# **A1 in Northumberland: Morpeth to Ellingham**

**Scheme Number: TR010059**

## **Applicant's Response to Relevant Representations**

<b>Regulation Reference:</b>	APFP Regulation Rule 8(1)(c)
<b>Planning Inspectorate Scheme Reference</b>	TR010059
<b>Application Document Reference</b>	TR010059/6.7
<b>Author:</b>	A1 in Northumberland: Morpeth to Ellingham Project Team, Highways England

**Trees to be Removed and Replaced at Coronation Avenue  
WQ LV.1.8**

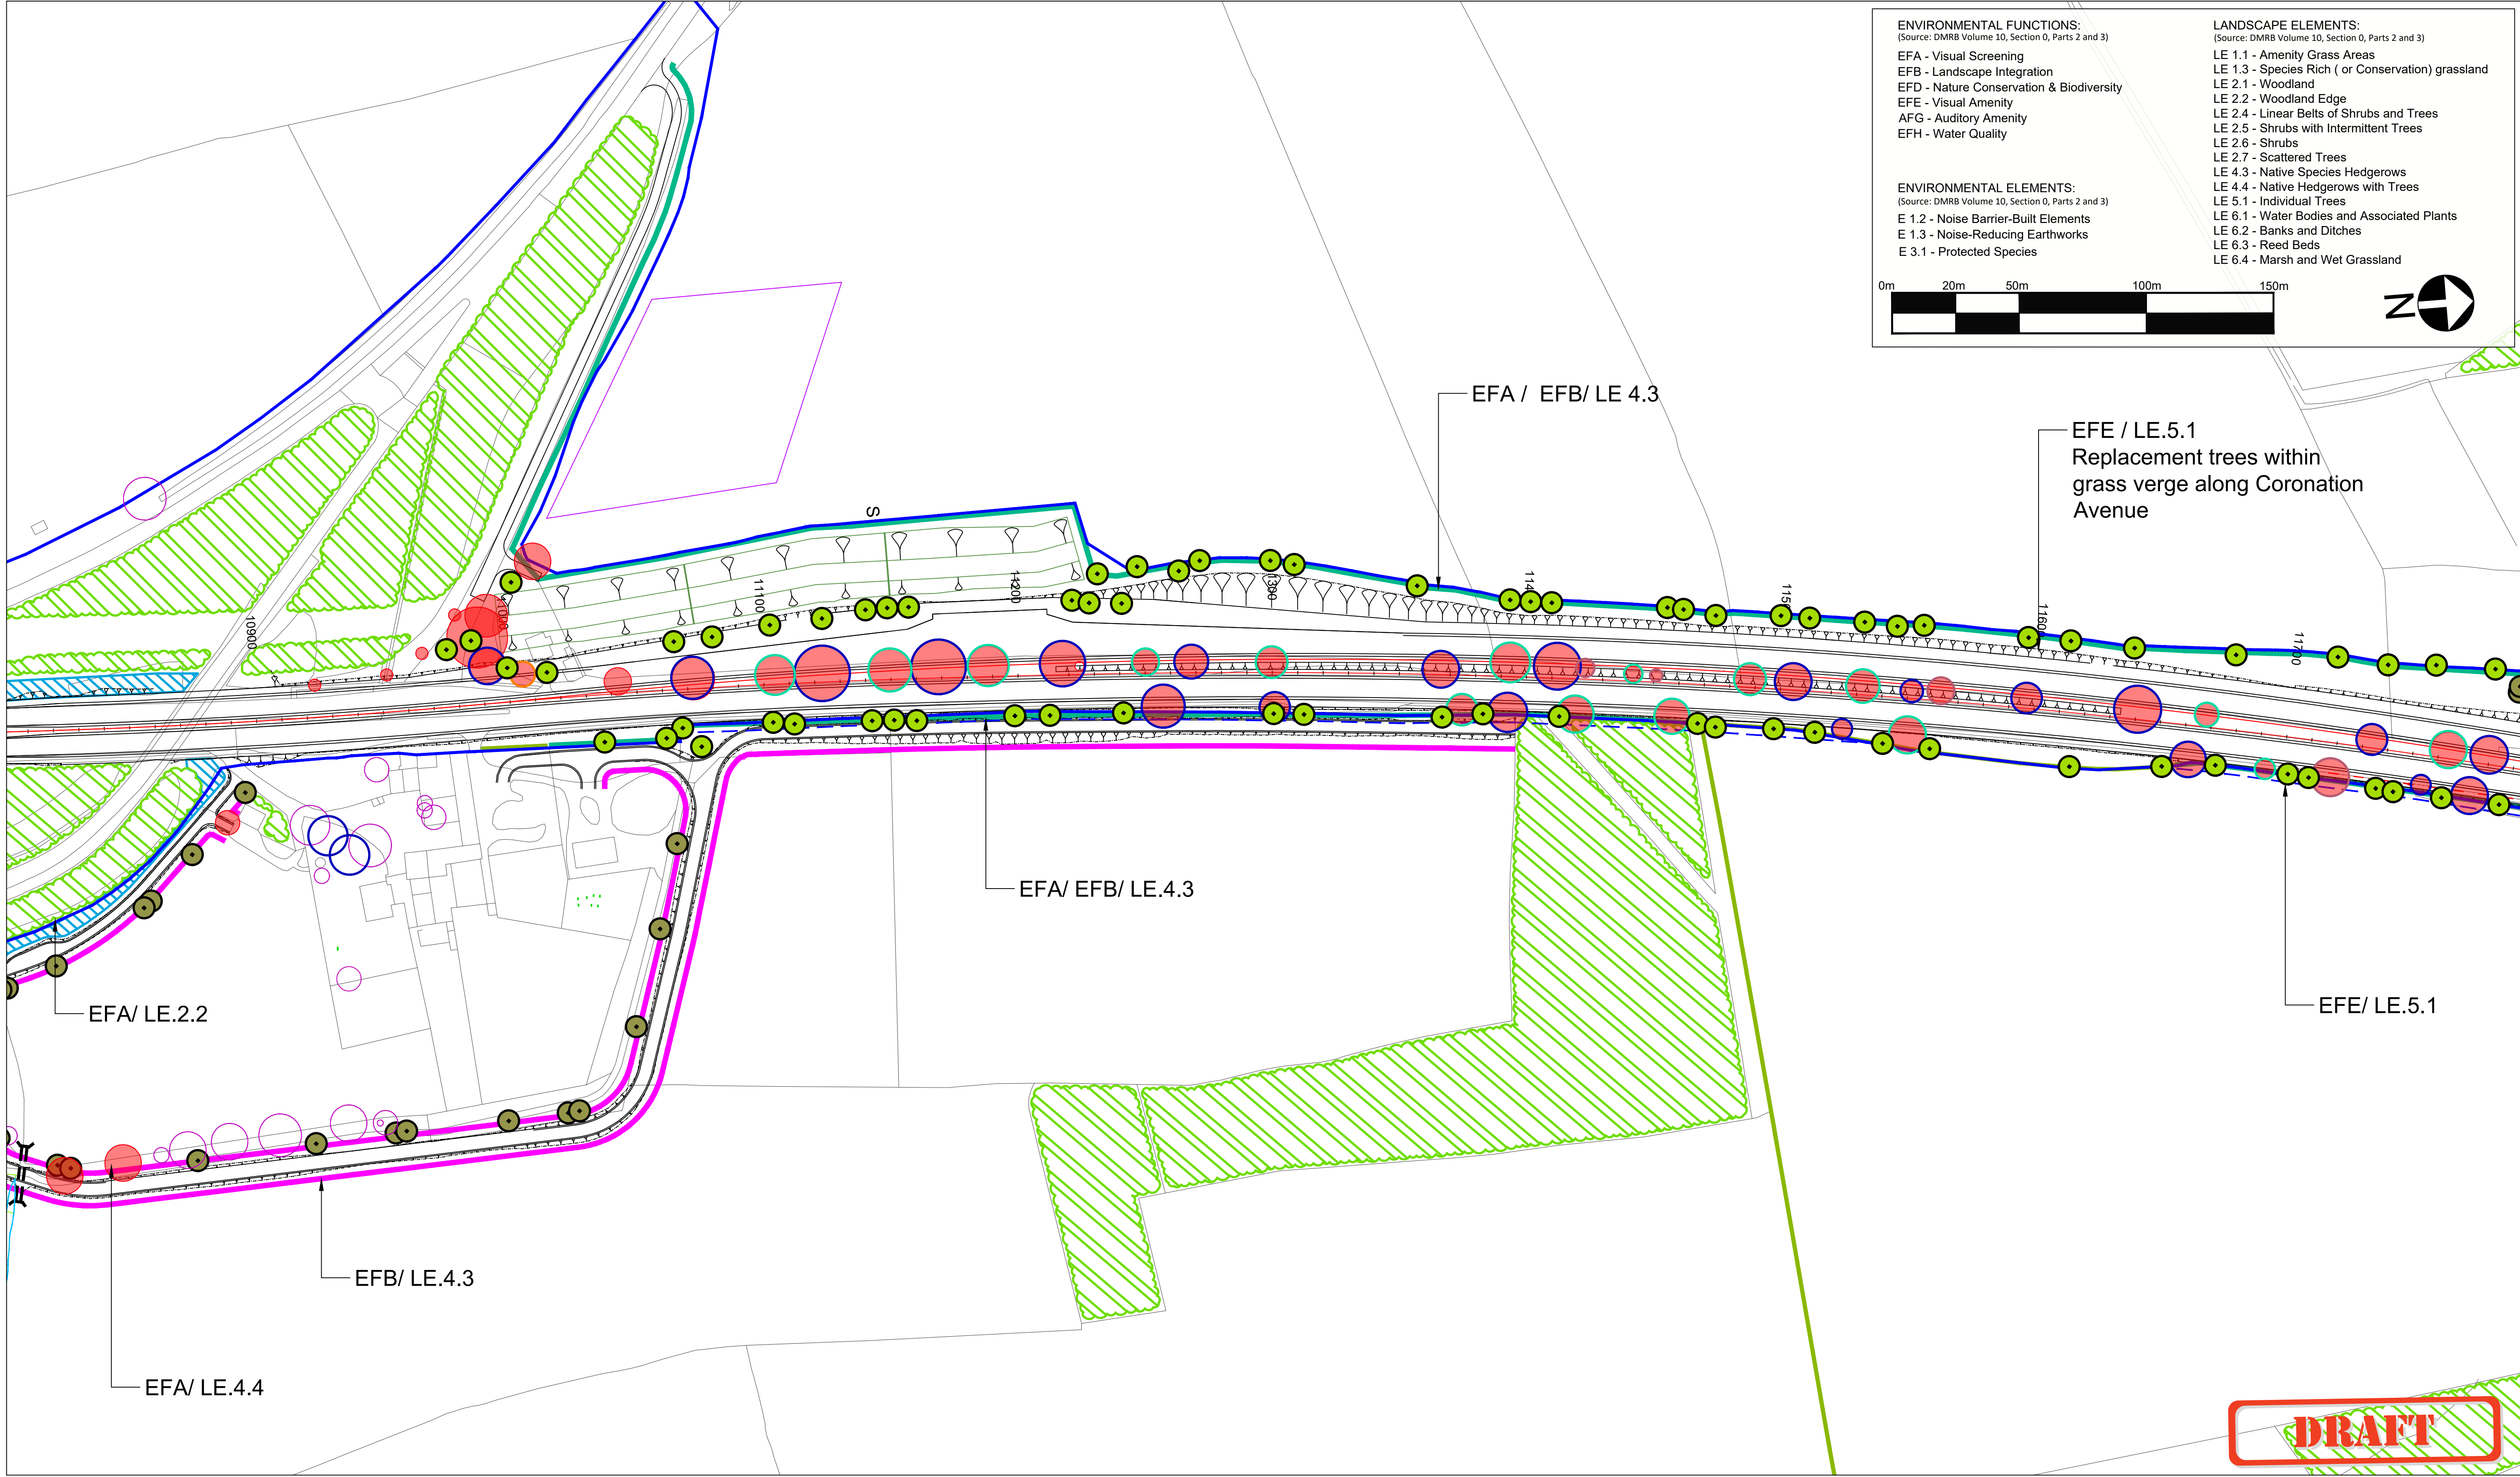
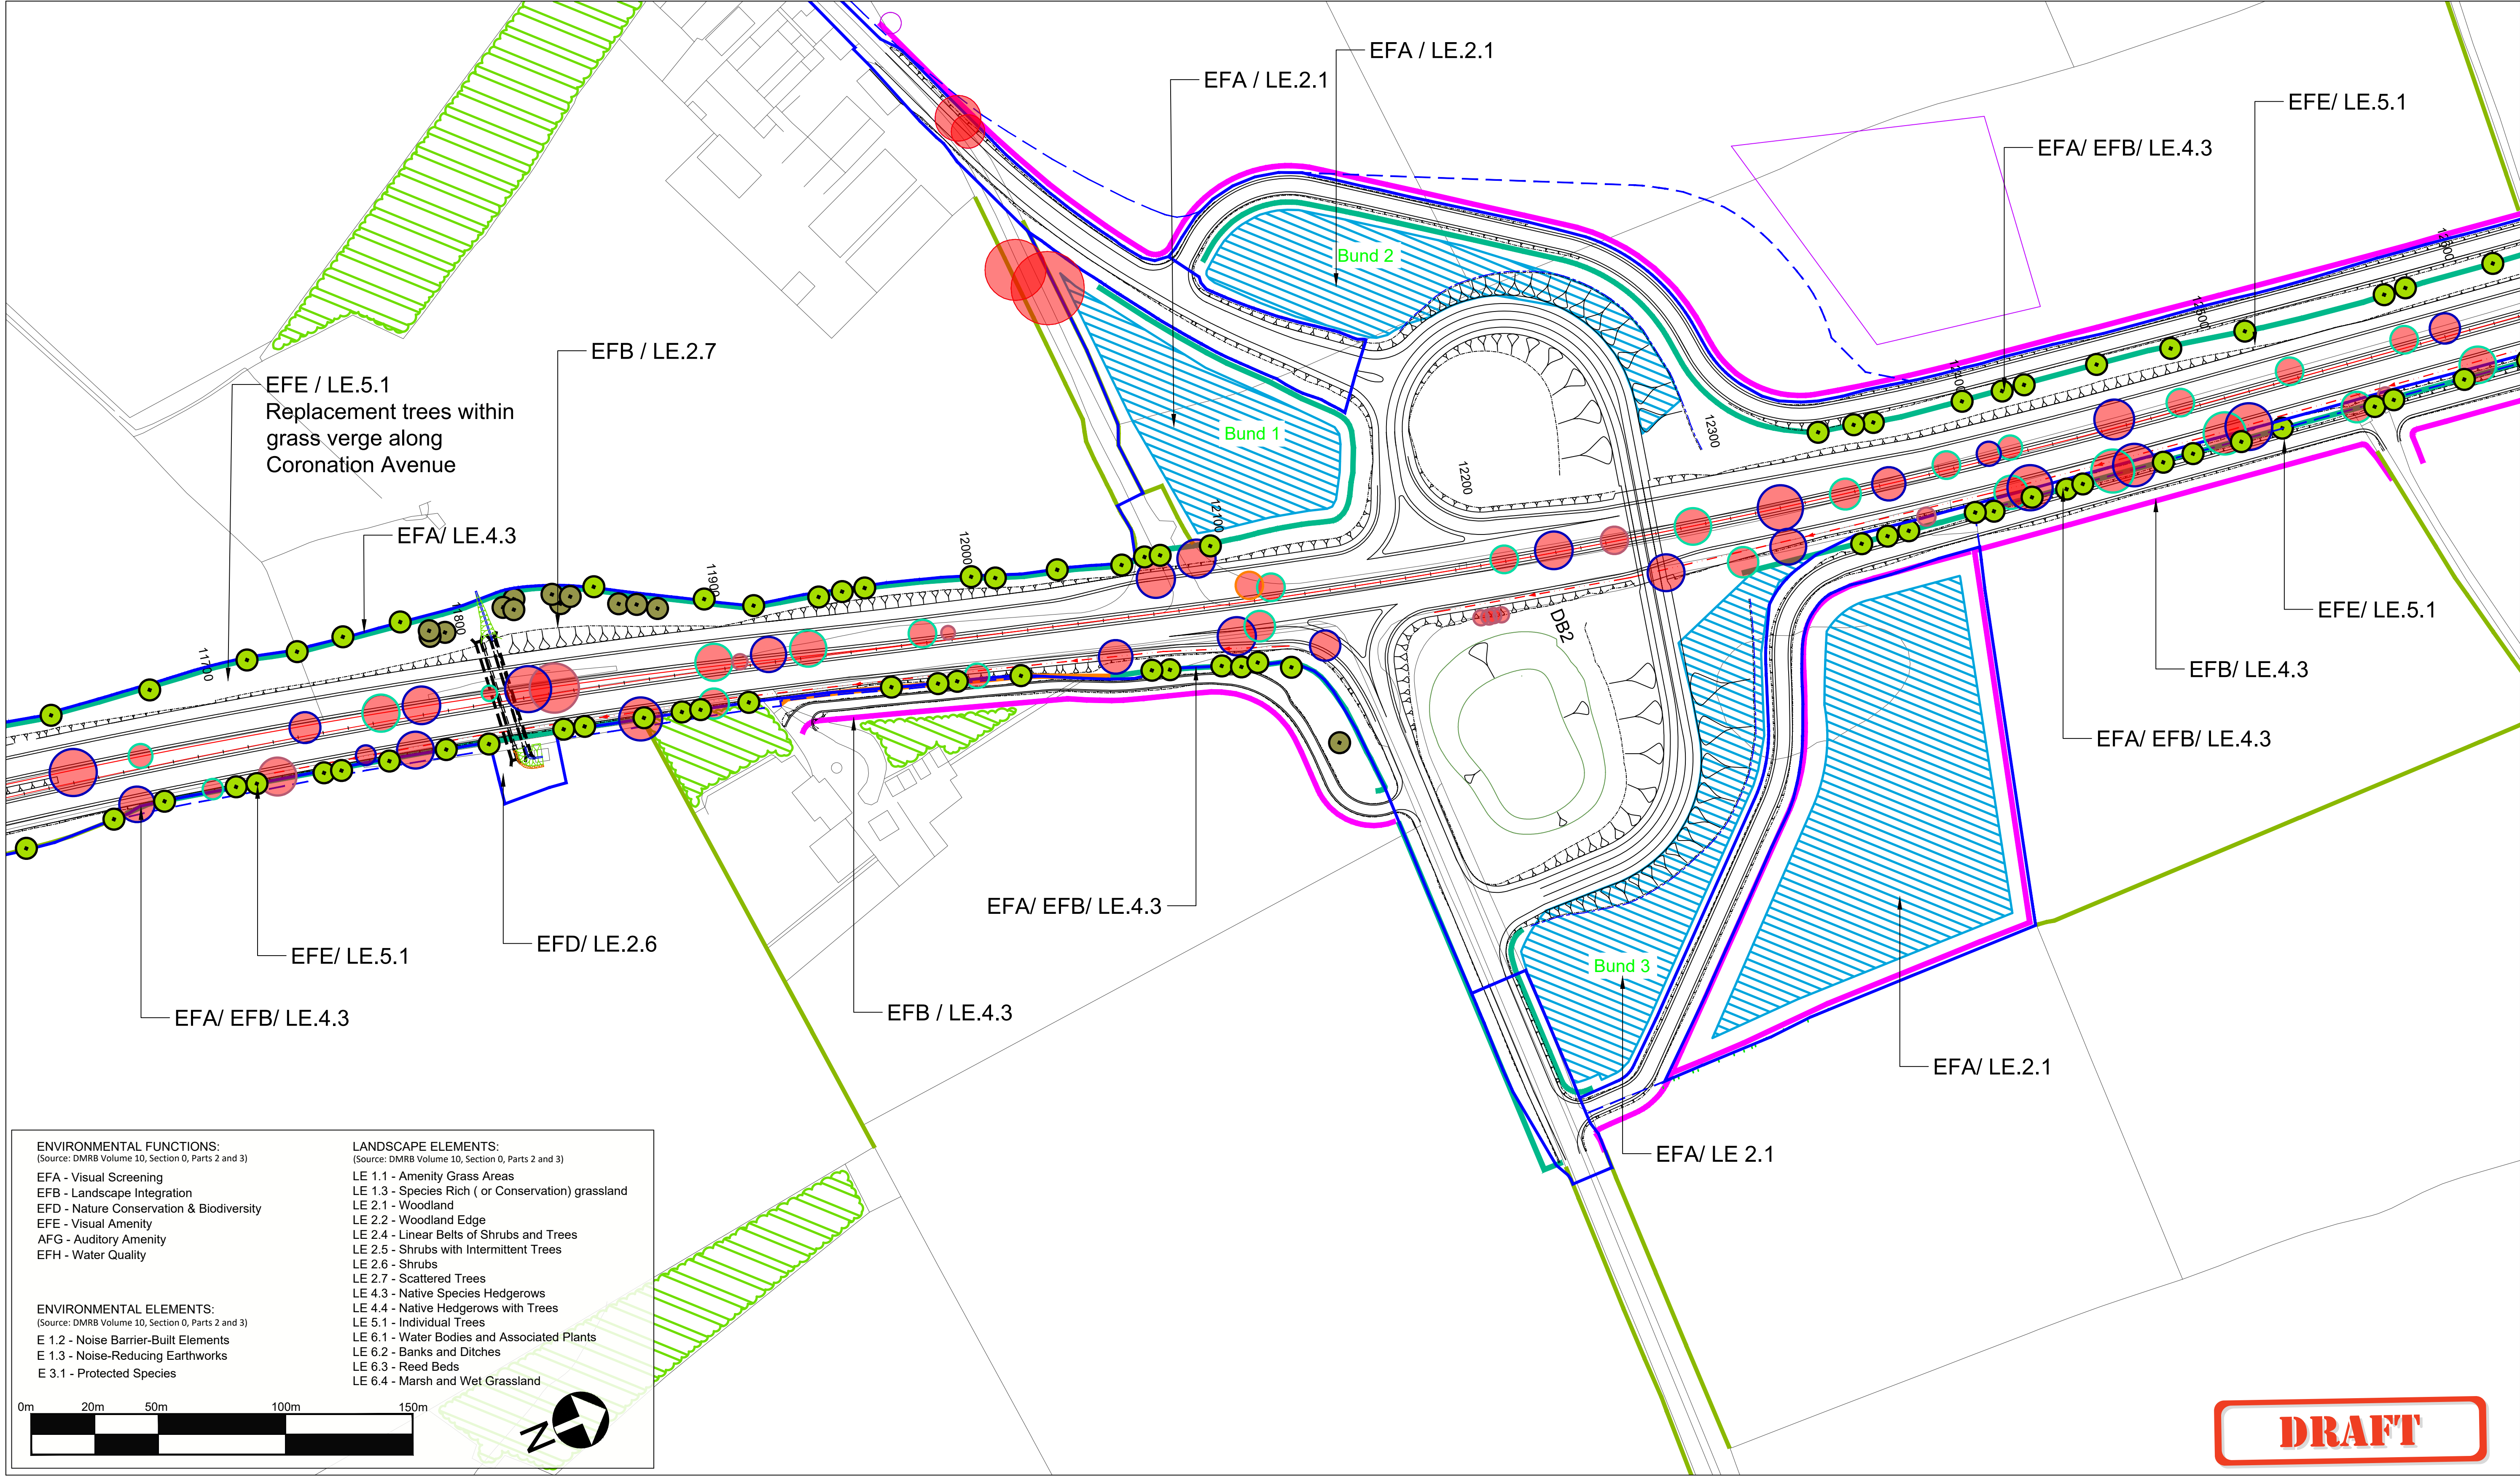
1.1.23	<p>The replacement Coronation Avenue is a token gesture, consisting of trees spaced roughly every 100m. This avenue plays an important role in retaining a rural, well vegetated character through this section of the route and the LVIA is quite clear about the local importance of the Avenue as a landscape feature and the sparse nature of the replacement compared to what is removed is not explained or justified in the application.</p>	<ol style="list-style-type: none"> <li>1. In paragraph 7.8.10 of Chapter 7: Landscape and Visual, Part A [APP-044] it is acknowledged that 187 no. of the 300 no. trees that form the Coronation Avenue would be removed by the Scheme. Figure 7.8: Landscape Mitigation Masterplan Part A, [APP-095] identifies the indicative location of the replacement trees, at regular intervals along the extent of the A1 where the presence of trees planted as part of the Coronation Avenue currently exist, totalling 38no. As has been identified above, the Landscape design as set out in Figure 7.8: Landscape Mitigation Masterplan Part A, [APP-095] including any replacement vegetation and trees to restore the Coronation Avenue will be approved by the Secretary of State following consultation with NCC as per Requirement 5, Schedule 2 of the draft DCO [APP-014]. The Applicant has prepared a draft strategy for the replacement of trees along the Coronation Avenue, identifying the final number and spacings of the replacement trees that would be planted to restore the landscape feature, refer to Appendix LV.2 submitted at Deadline 1 in response</li> </ol>

Reference	Comment from Relevant Representation	Applicant's Response
		to ExA Written Question LV.1.8, having been discussed and agreed with NCC via email January 2021.
